RE: Addison Galaxy FBO

Attached are the revised plan sheets for the "ASI-C003" revision to the civil plans based on the review comment we received back from the Town last week. We also took this opportunity to reflect that the decision has been made to have steps for the door coming out of the south end of the FBO building, so below is a complete list of the sheets included in ASI-C003 to indicate what, if anything, was changed on each of the sheets since we submitted this revision previously.

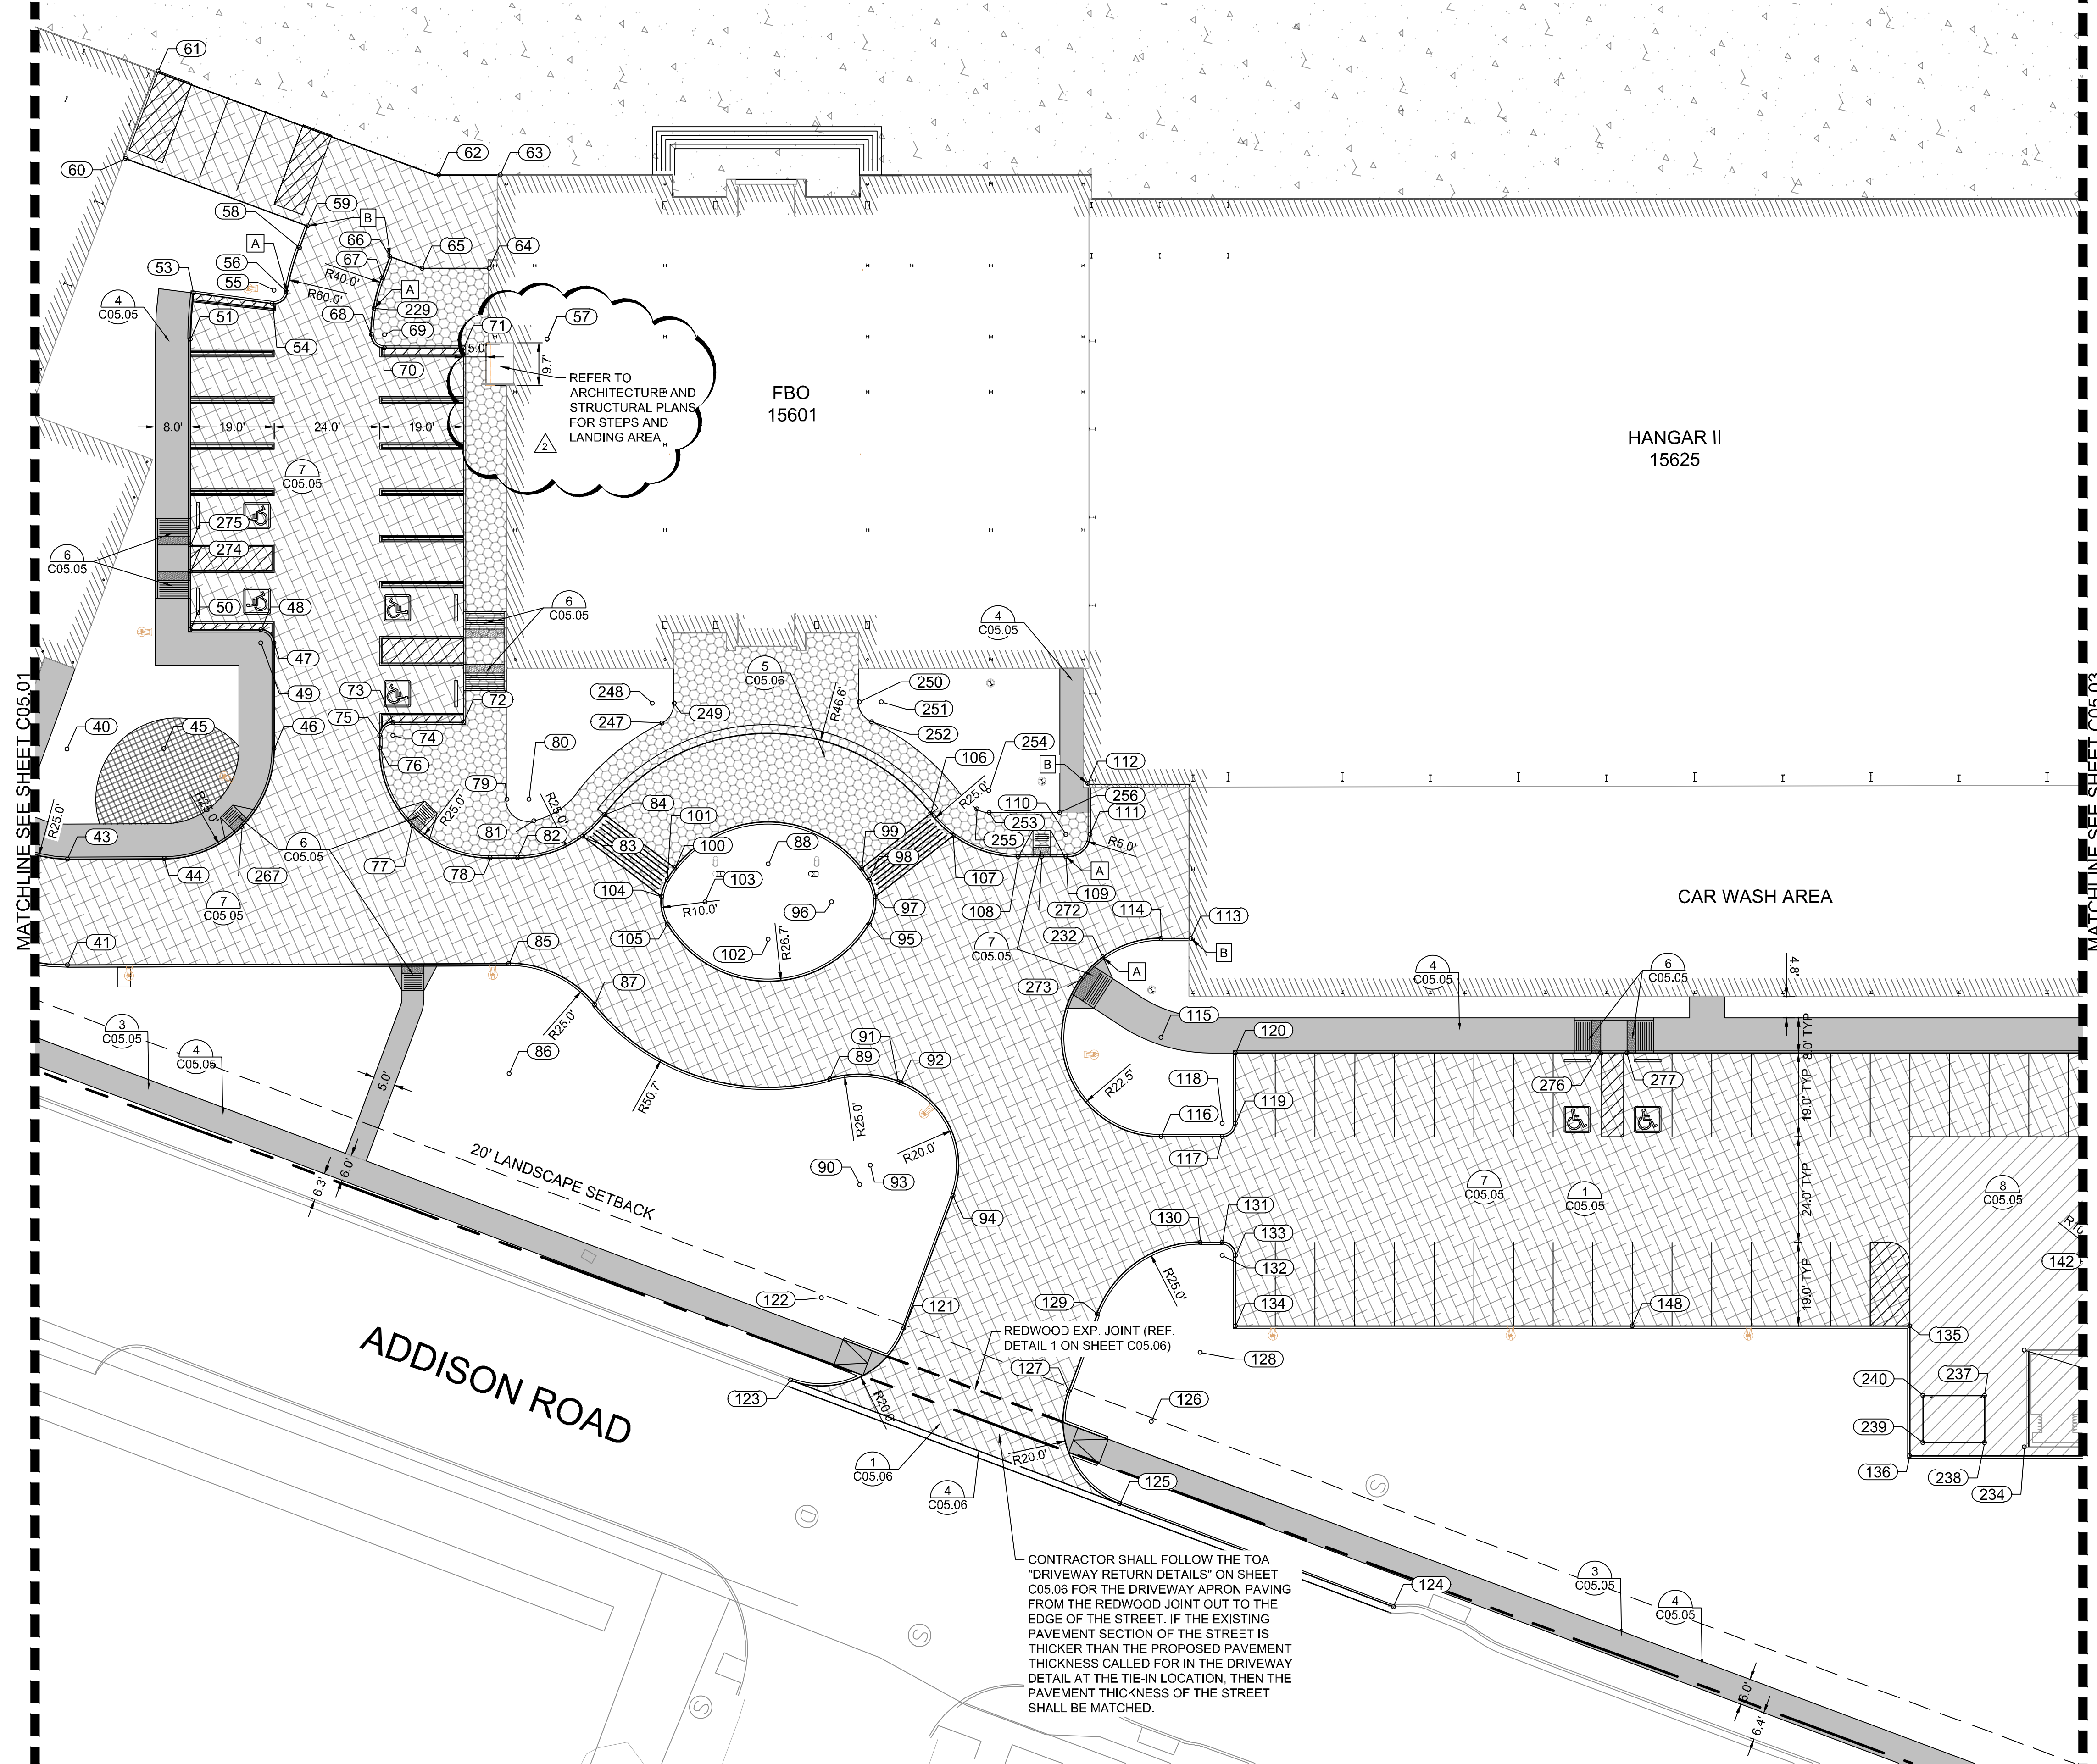
- C05.02 Geometry Landside – updated the FBO building background to show steps in lieu of a ramp at the south end of the FBO building.
- C07.01 LANDSIDE JOINT LAYOUT PLAN – no changes since the original submittal of ASI-C003

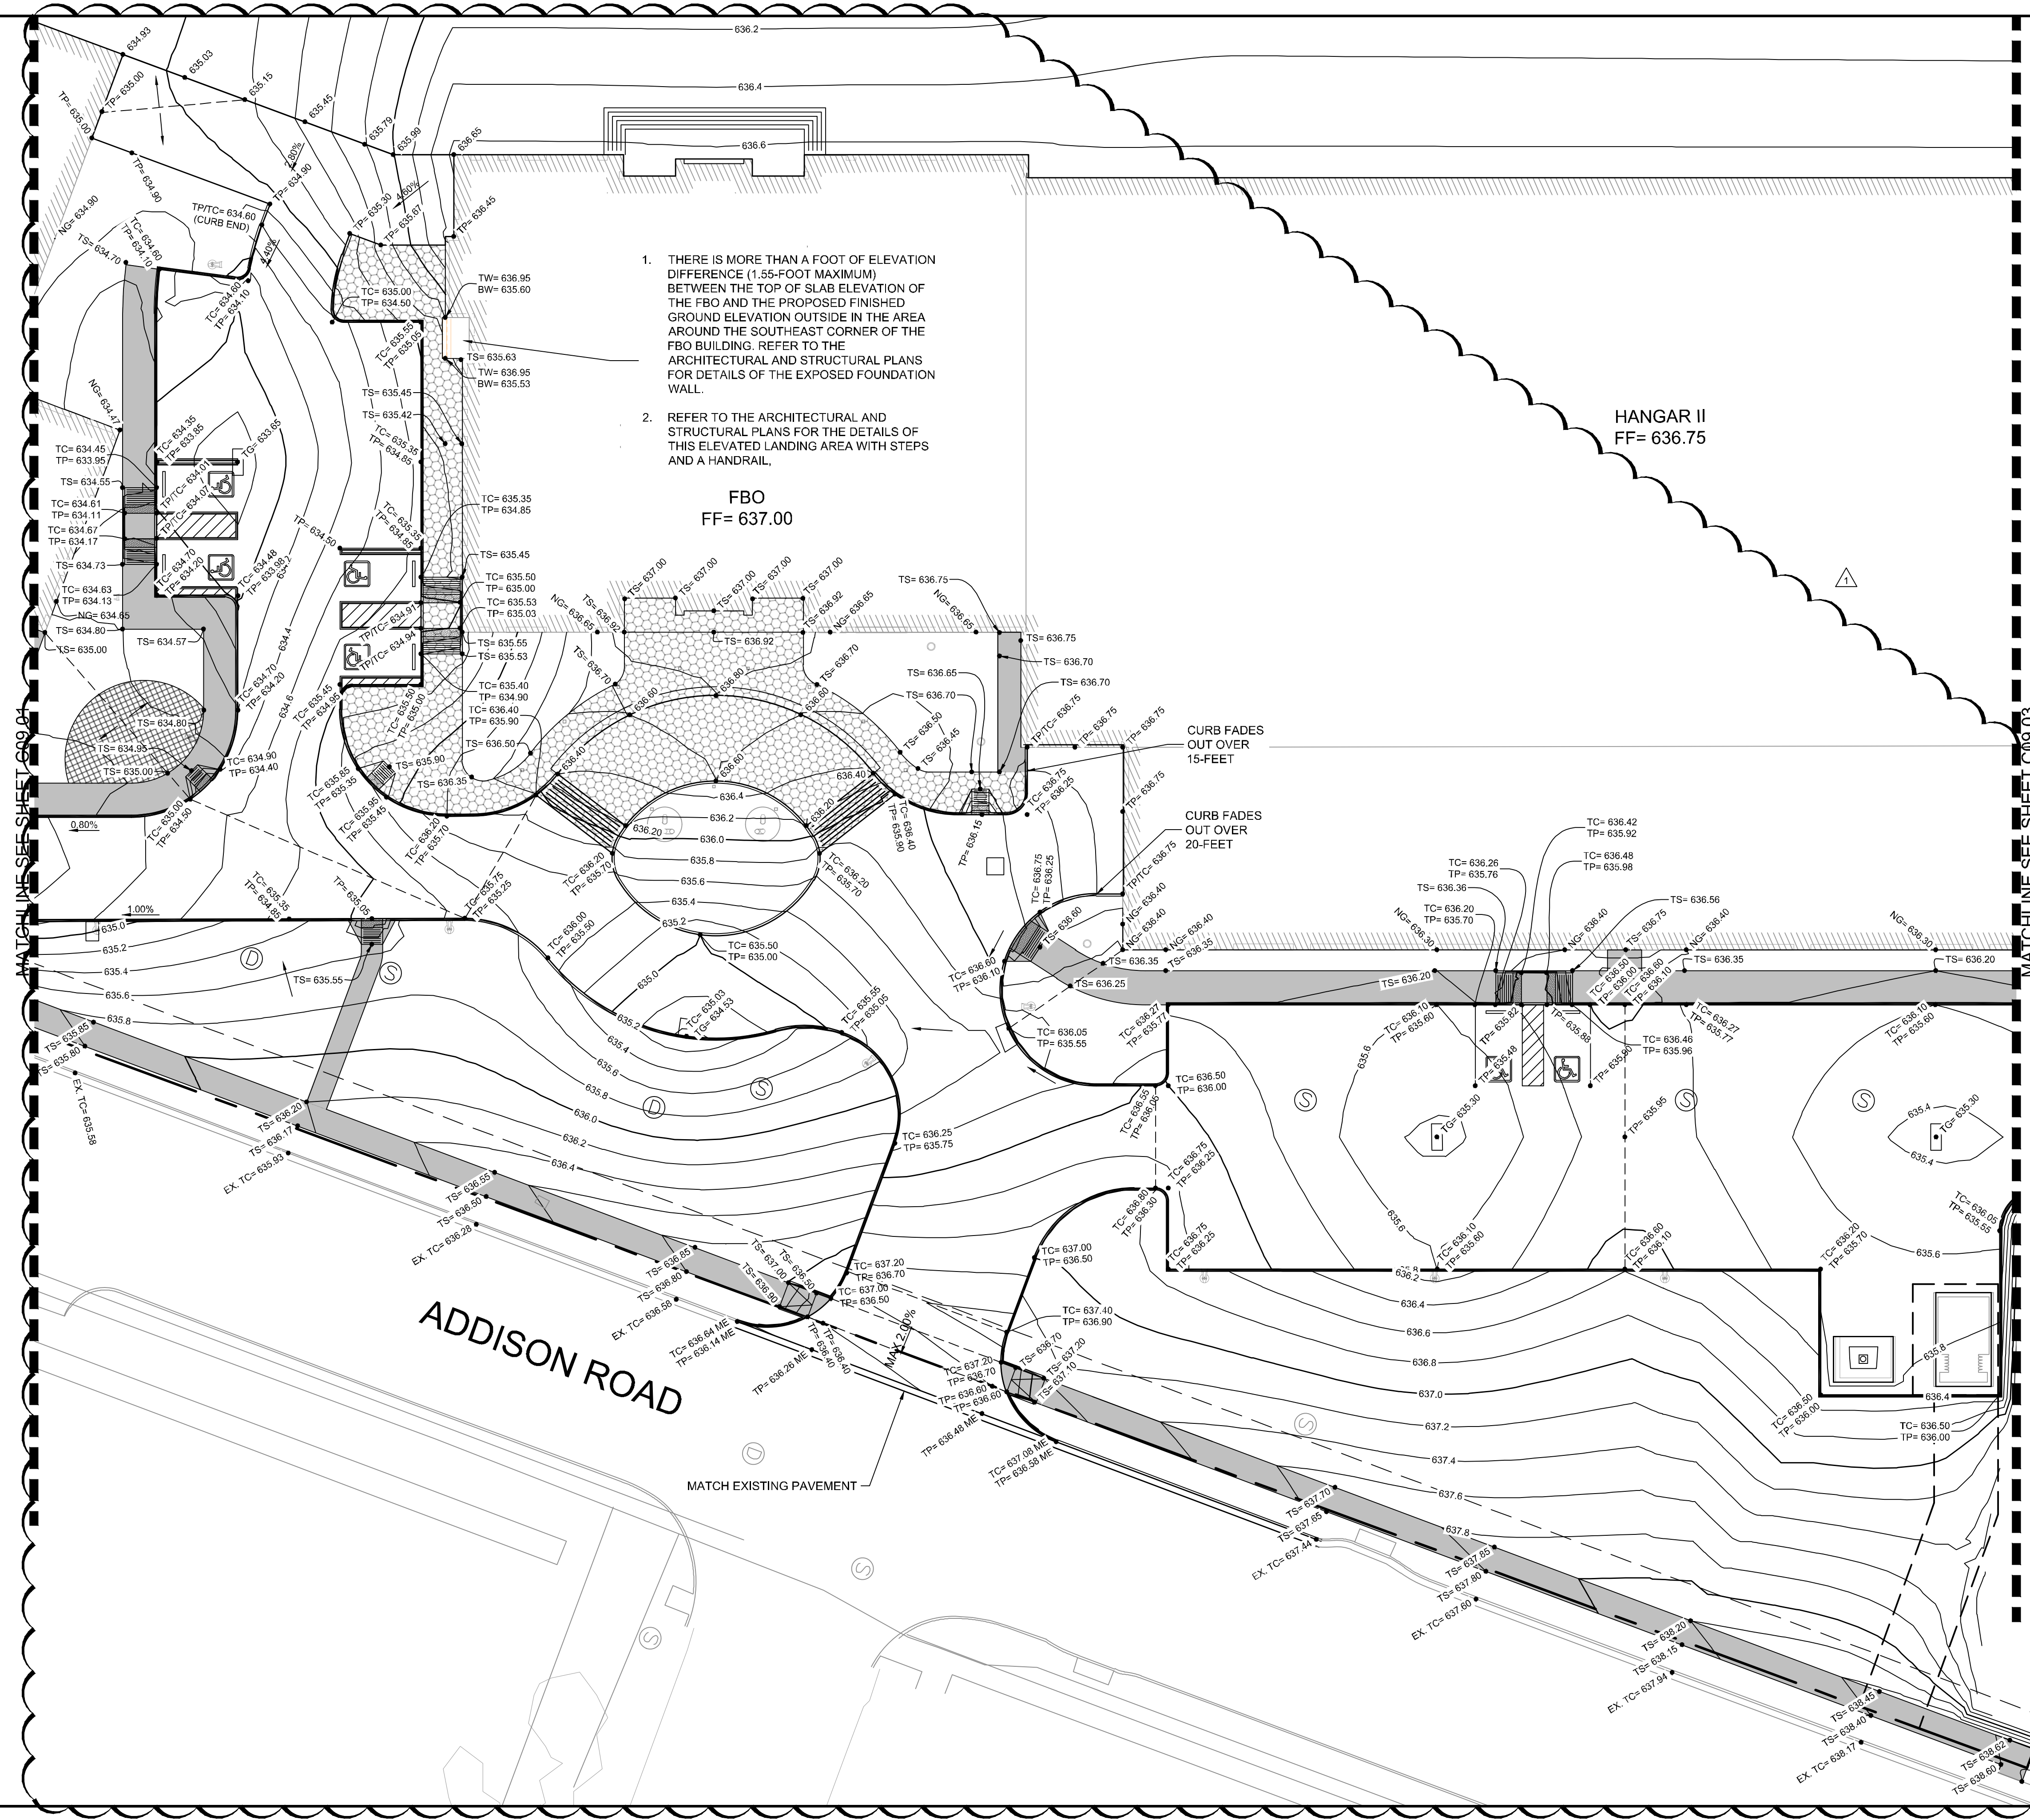
- C09.02 LANDSIDE PAVEMENT ELEVATION PLAN – updated the FBO building background to show steps in lieu of a ramp at the south end of the FBO building, and updated spot grade elevations in the area around the steps.

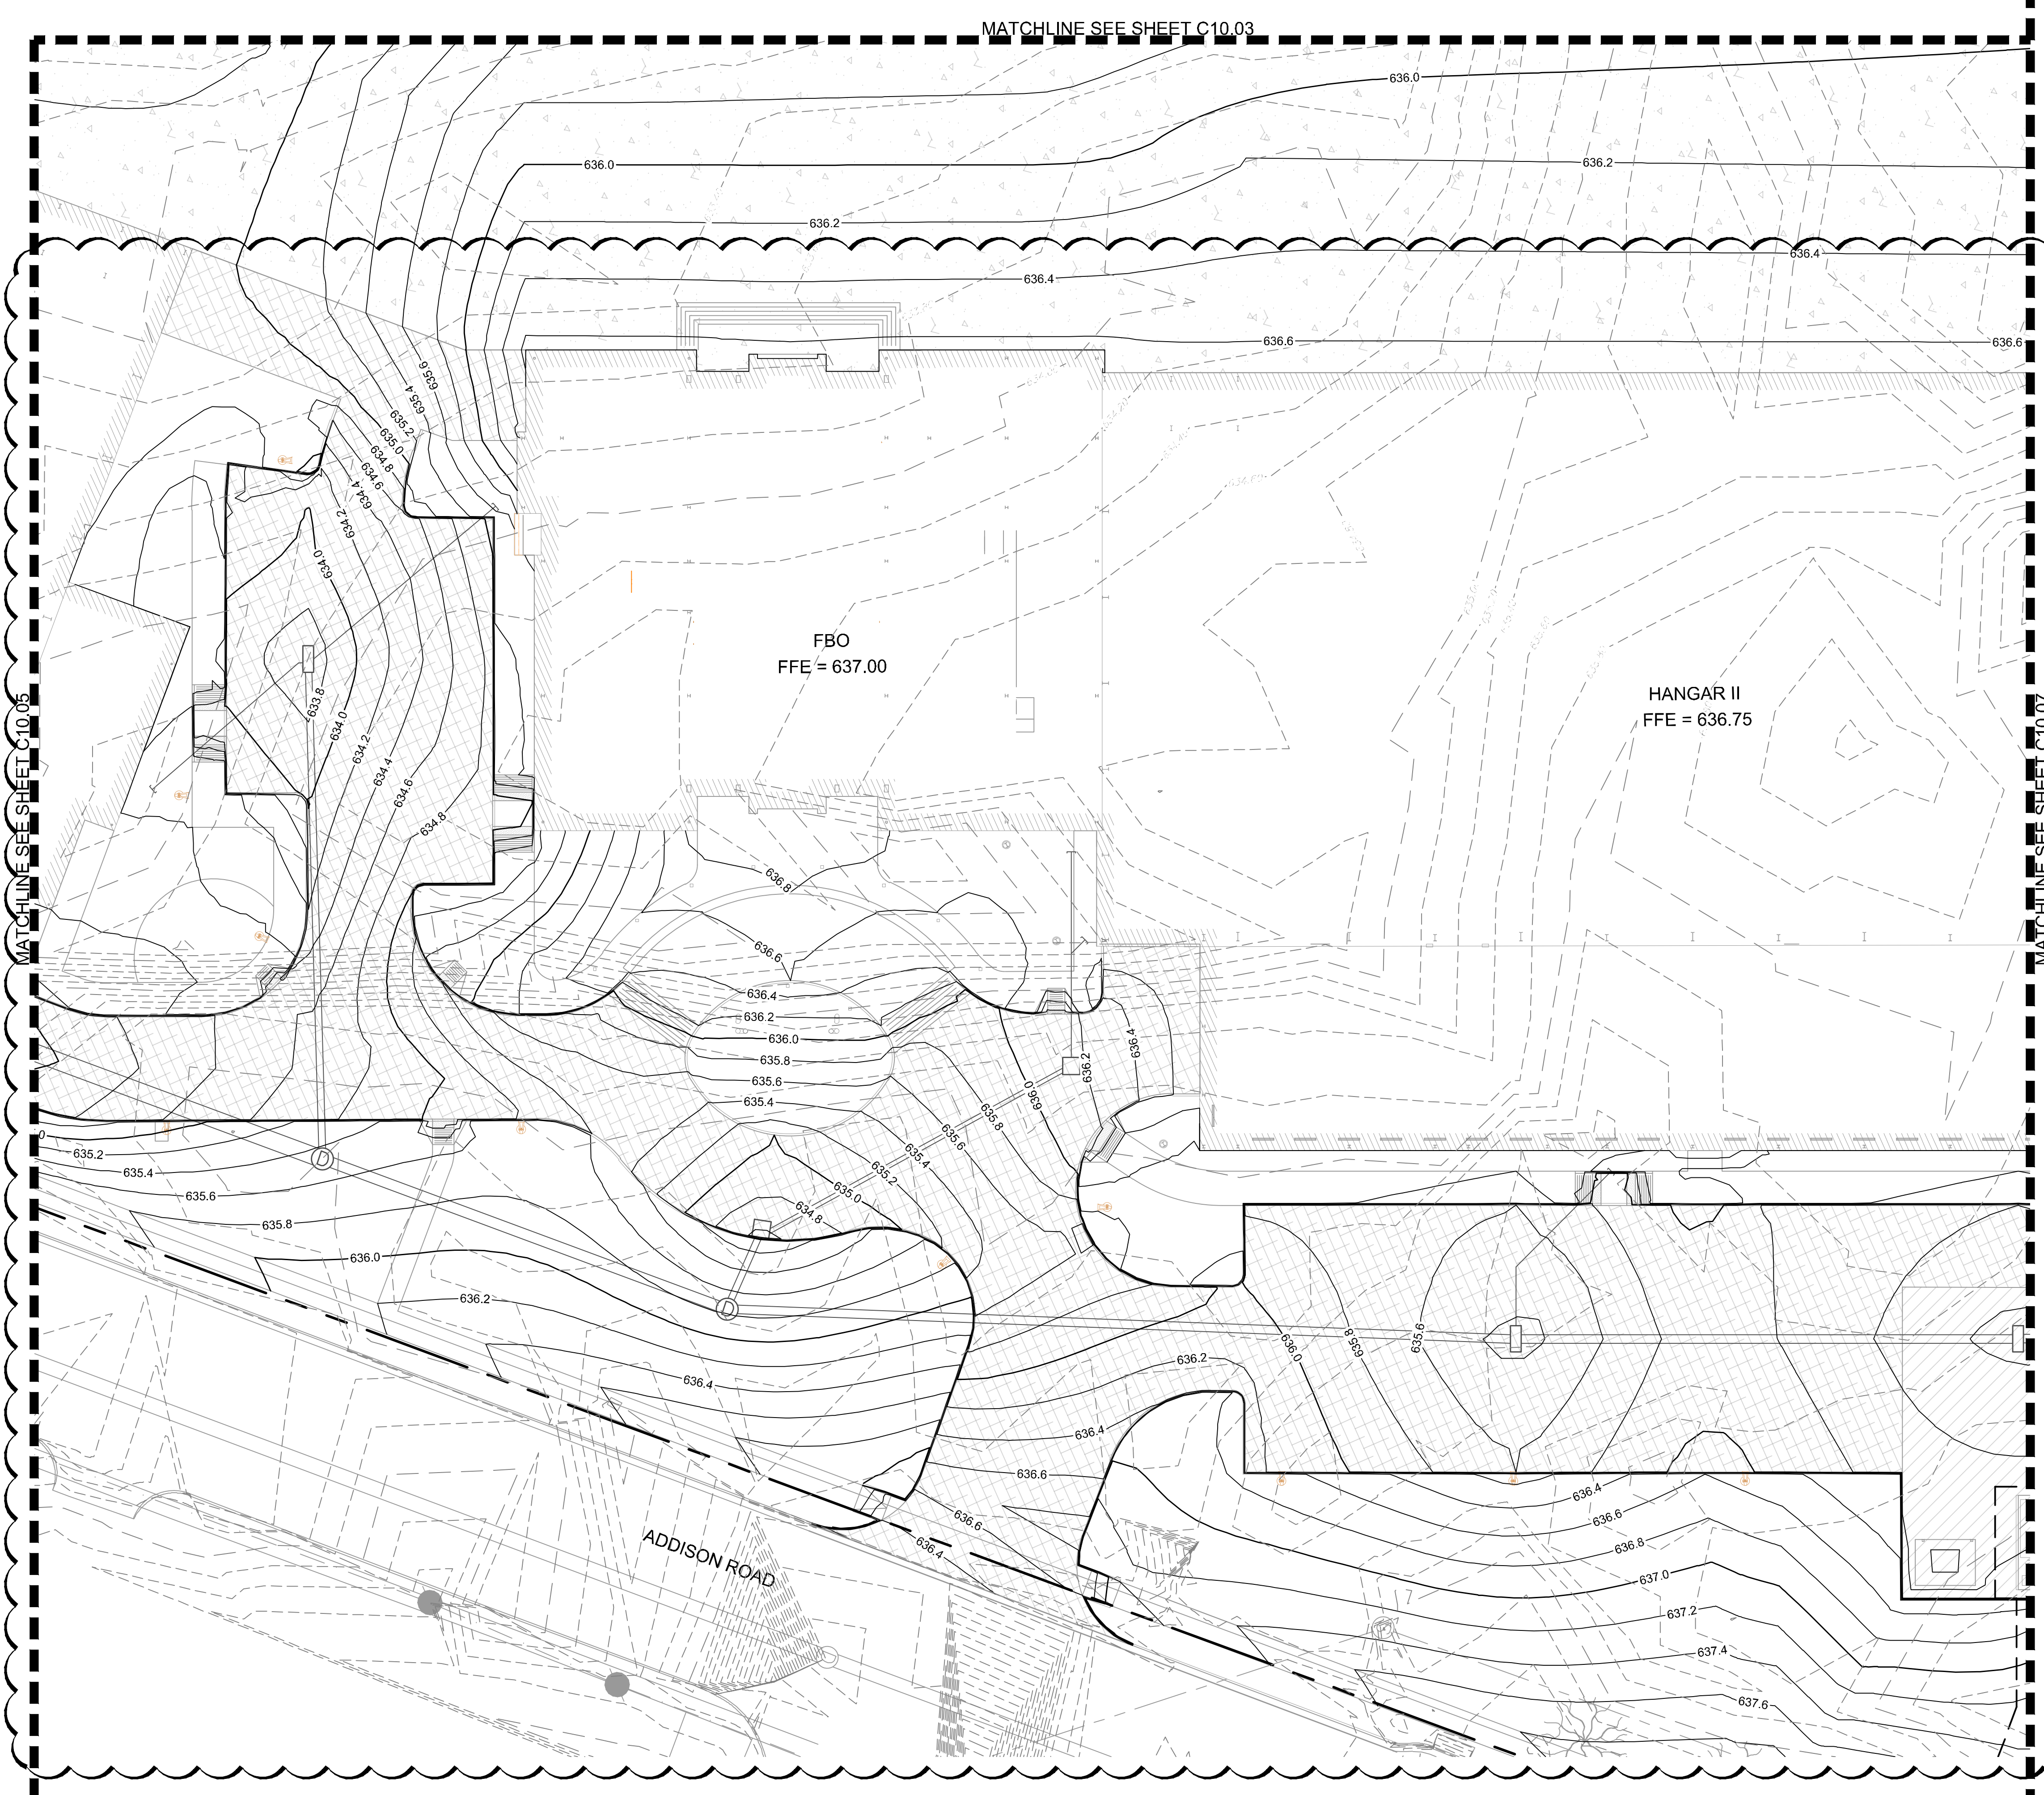
- C10.05 GRADING PLAN – no changes since the original submittal of ASI-C003
- C10.06 GRADING PLAN - updated the FBO building background to show steps in lieu of a ramp at the south end of the FBO building, and updated grading in the area around the steps.
